Address: Janines Hair Salon, 65 The Town Dewsbury Wf12 0qx

Application number: 2024/92694	
What is the application for?:	Erection of side and rear extensions and raised deck
Address of the site or building:	63, The Town, Thornhill, Dewsbury, WF12 0QX
Postcode:	WF12 0QX

Drawing Title
PROPOSED

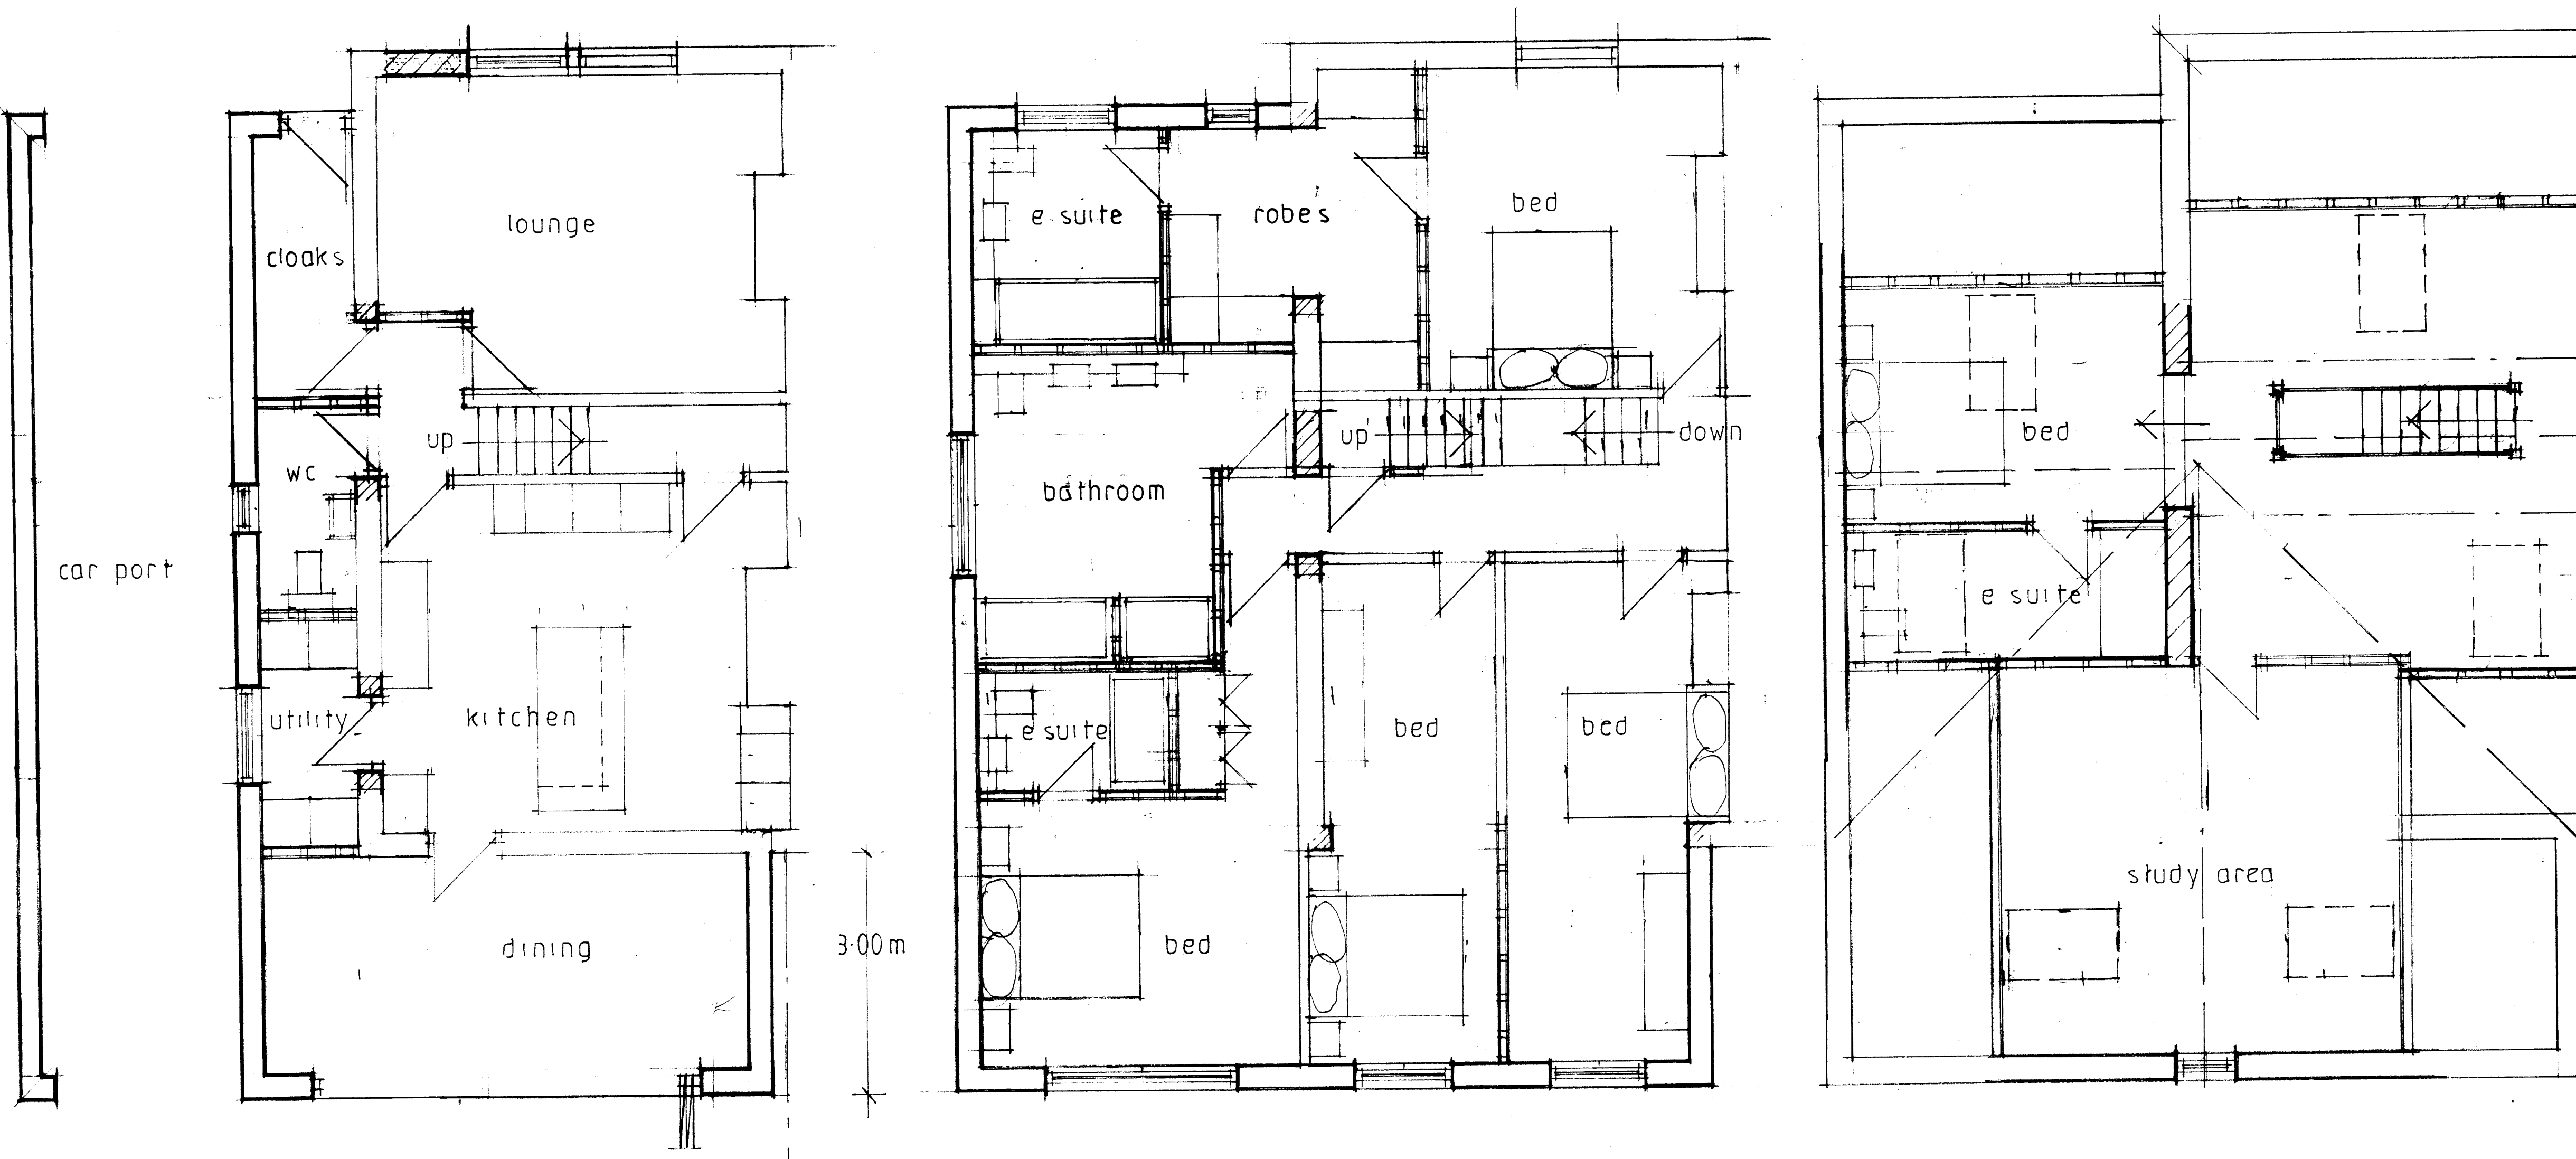
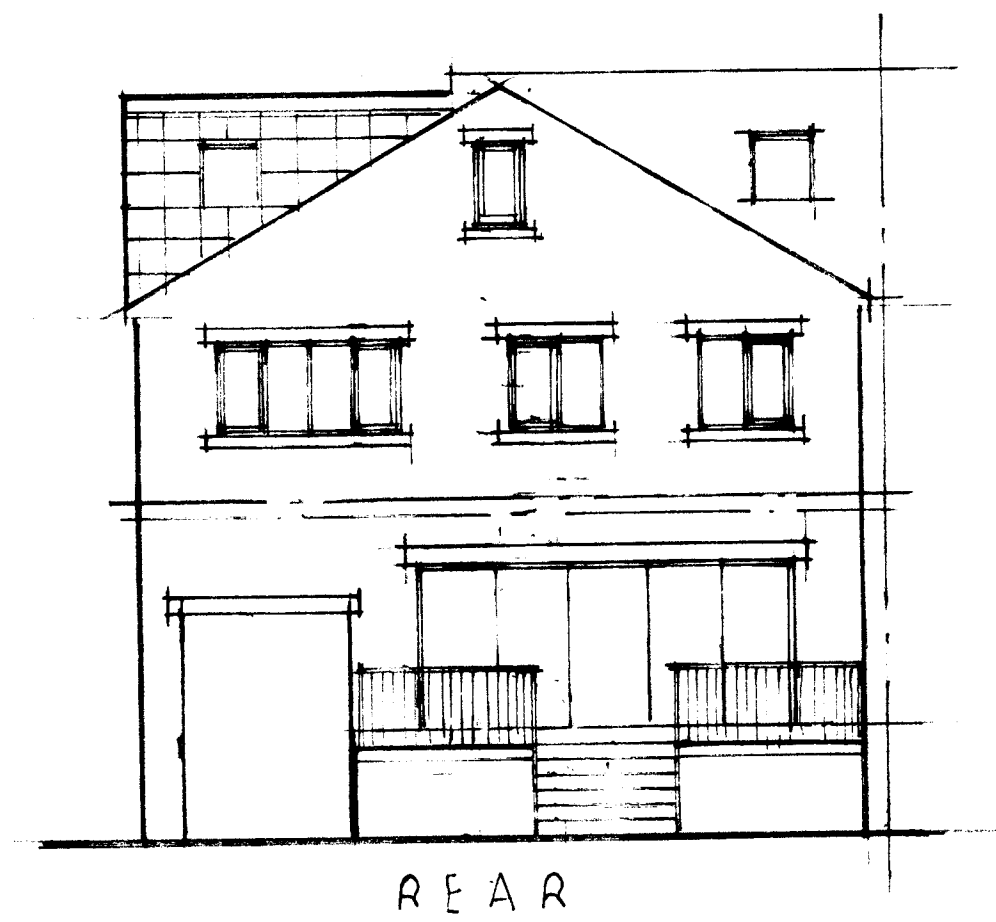
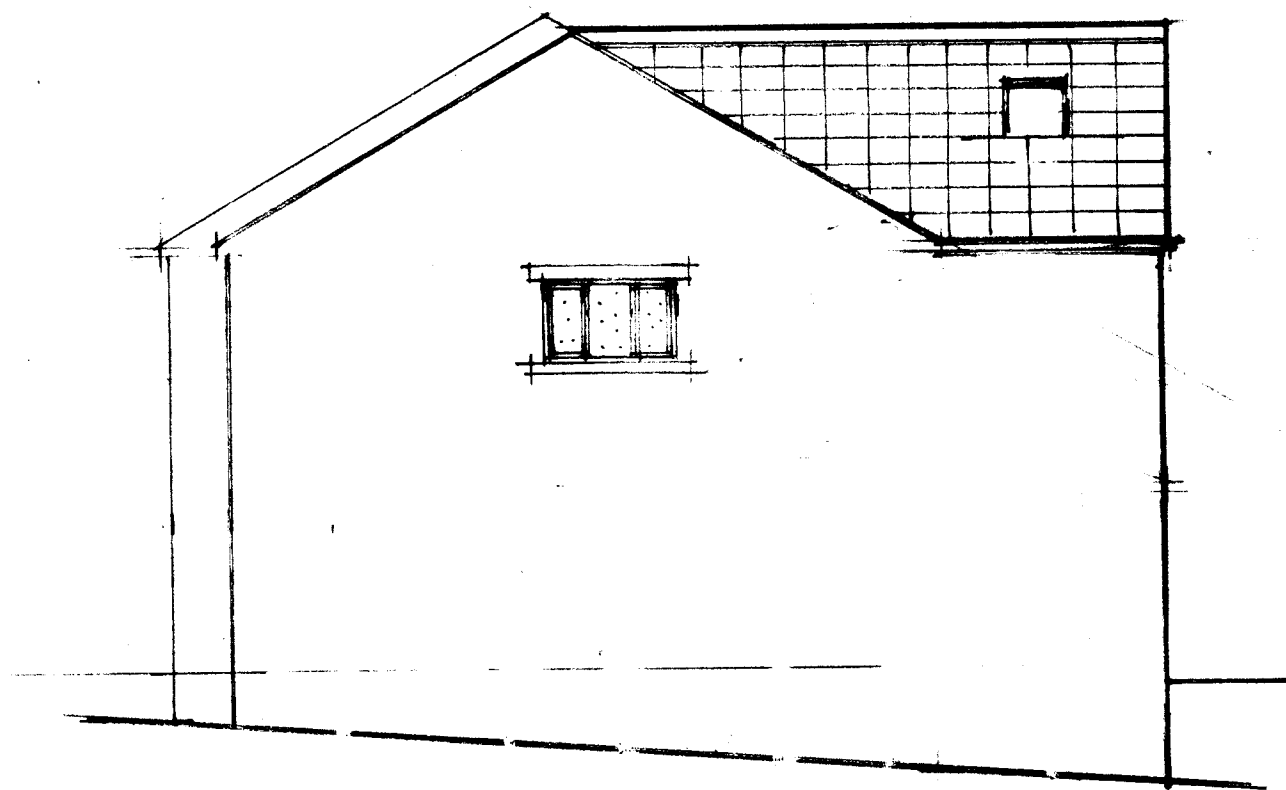
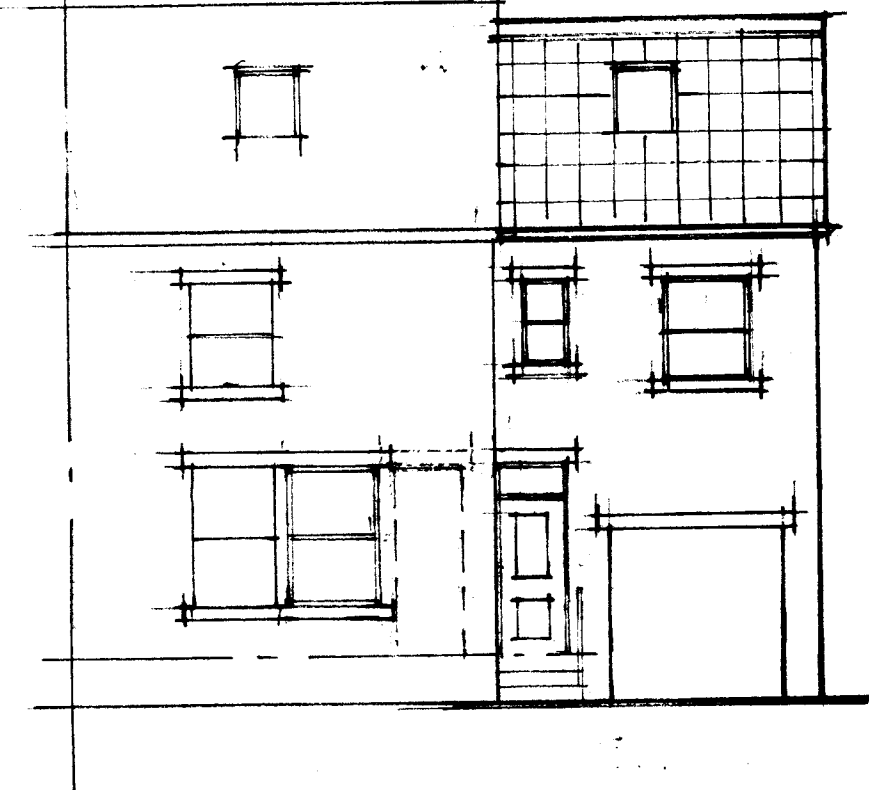
Type of comment: A general comment	
Do you wish your comments to be published on the website anonymously?	No
<p>I'm the owner of the building next door which is my business (hair salon). My concerns are as follows</p> <p>Drainage and water issues,as under no circumstances can I be left without water under any period of time whilst the build is on going.</p> <p>Our windows at the side of our property run alongside the proposed plans blocking any natural day light into our property and leaving barely any gap between both properties.</p>
